## REP7-042 9.46 Applicant Response to D6 Submissions (Rev 1)

### D6R29 Air Quality and Emissions Response

Figure C.2: Impacts from Unplanned Emissions at Eastern BESS Compound

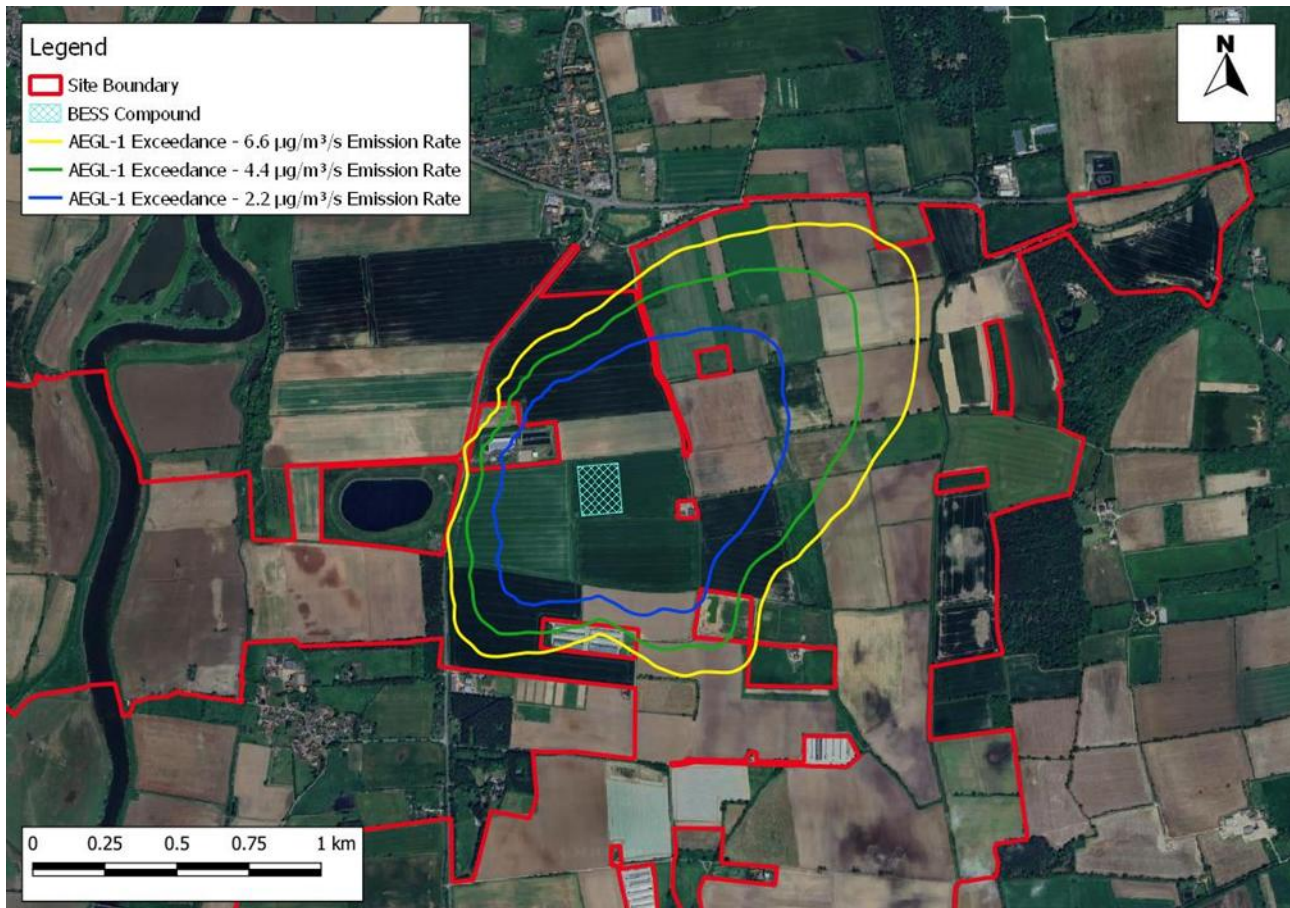
Even if the Poultry Sheds and Water Treatment Plant are not deemed to be a sensitive receptor, which I would disagree with given the above information, there is a residential dwelling at Northfield Farm and therefore I would still challenge the accuracy of REP7-022 7.11.6 Outline Battery Safety Management Plan (Clean) (Rev 7), C.4.4.1 where it states “no sensitive receptors” in relation to unplanned emissions at the Eastern BESS Site as there is at least one which meets the definitions the Applicants have provided as evidence to back their suggestion there isn’t any.

Below is Figure C.2: Impacts from Unplanned Emissions at Eastern BESS Compound from the oBSMP. I have highlighted the Anglian Water, Water Treatment Plant and Northfield Farm and Bungalow in pink.

Northfield Poultry Sheds and Residential Property, highlighted by the pink circles.

Clearer image of the Anglian Water, Water Treatment Plant.
